Cambridgeshire County Council (20031358)
East Cambridgeshire District Council (20031149)
Suffolk County Council (20031377)
West Suffolk Council (20031311)

The Councils' position on 'parcel by parcel' mitigation and residual effects

Sunnica Energy Farm (EN010106)

3 March 2023

Drawing Title
**ENVIRONMENTAL MASTERPLAN
 DETAILED PLANS
 SHEET 4
 EAST SITE A**

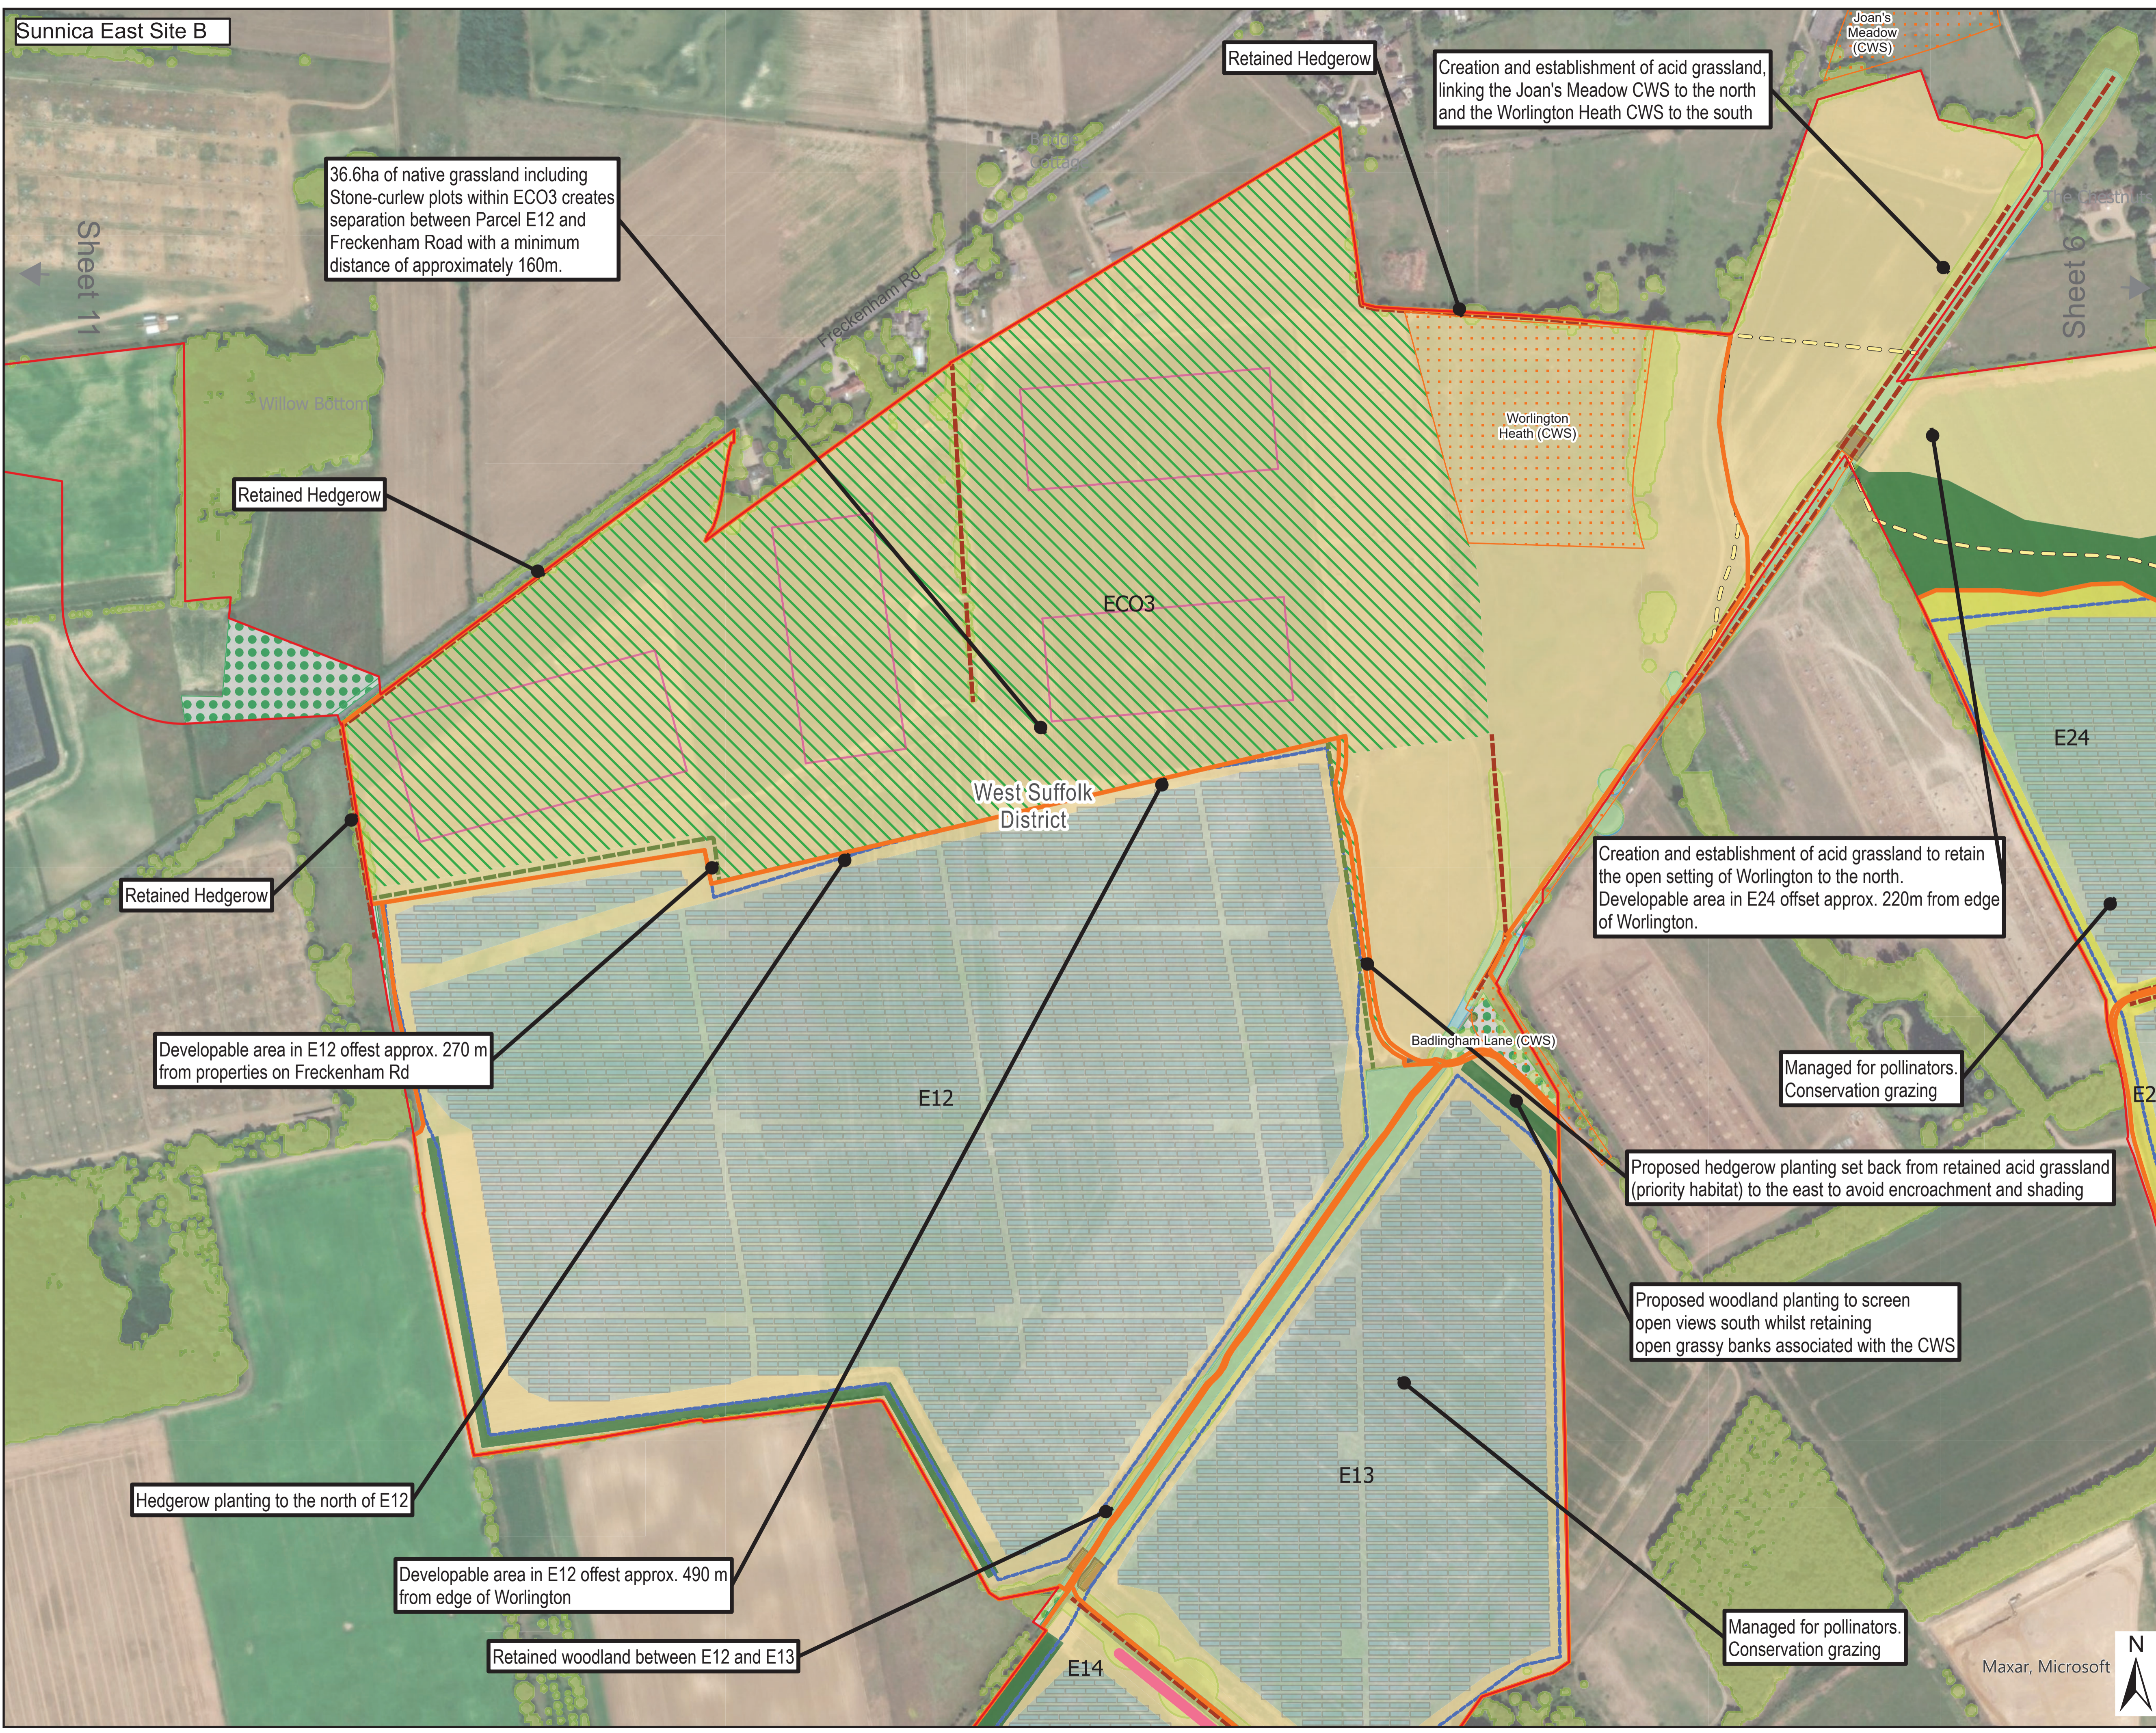
E04	-Additional broadleaved woodland along the northern, southern and the eastern edges	-Potential for truncation of long- distance views of the Ark and St Andrews Church in Isleham.	-Consider if, views from the residential properties on Ferry Lane to The Ark and St Andrew’s Church in Isleham could be retained (see VP2C), with appropriate adaption of the proposed mitigation planting and siting of structures within E04.	-	-
E33	-Siting the primary construction compound, BESS and substation in E33 adjacent to reservoirs and Lee Farm, so that their massing and land uses are perceived in the context of existing infrastructure features and built structures in the landscape. -The tonal rendering of shades to integrate the permanent structures within the landscape will help to reduce their perceived overall mass.	-BESS and substation will remain visible in the landscape from the edge of Isleham (VP3), River Lark (VP 01, 2A and 2B), Ferry Lane (VP2C) and the wider landscape to the south VP12A -Colour of external finishes for structures to be green, light grey or white	- Plant a tree belt/woodland along the western side of E33 (Bess and substations). (see VP1, VP6, VP7) -Subject to archaeological constraints, there appear to be opportunities for a more robust woodland planting scheme east of E33, which would help to screen the BESS even during winter conditions. (see VPs 2A and 2B) -Or adjust the position of the infrastructure here to allow sufficient space for effective mitigation (LIR 10.170) -Environmental colour Assessment to be undertaken at detailed design stage to inform the external finishes of the stuctures	-	-The BESS and other solar infrastructure would remain visible and incongruent in the landscape initially including from the R Lark, Isleham, Ferry Lane and the wider landscape to the south, although the effects would be tempered by the tonal rendering of shades of structures. -As the vegetation matures the effects would reduce particularly in the summertime although the planting would be uncharacteristic in the open flat landscape.

E08, E09 and E10	Parcels E08, E09 and E10 are enclosed by new hedgerows, to screen views of the panels and reinforce existing hedgerow patterns. There is also a proposed area of chalk grassland within E09, above an archaeological mitigation area	-BESS and substation will remain visible in the landscape from VP12A, VP12B and wider landscape to the south.	-Photomontage suggests wider set back than Landscape Masterplan. (see VP12A) - Woodland north of E08 needs to be wider as views are far reaching towards BESS. -For E09 and E10 consider how the second hedge can be adapted to strengthen and enhance the existing hedge on the southern boundary	- A second hedgerow is currently proposed along the southern edge of E09 and E10. Applicant to consider options for enhancing/increasing height of the existing hedgerow in this location	-Initially the BESS and substation will remain visible in the landscape from VP12A, VP12B and wider landscape to the south. -As the vegetation matures the effects would reduce particularly in the summertime although the planting would be uncharacteristic in the open flat landscape.
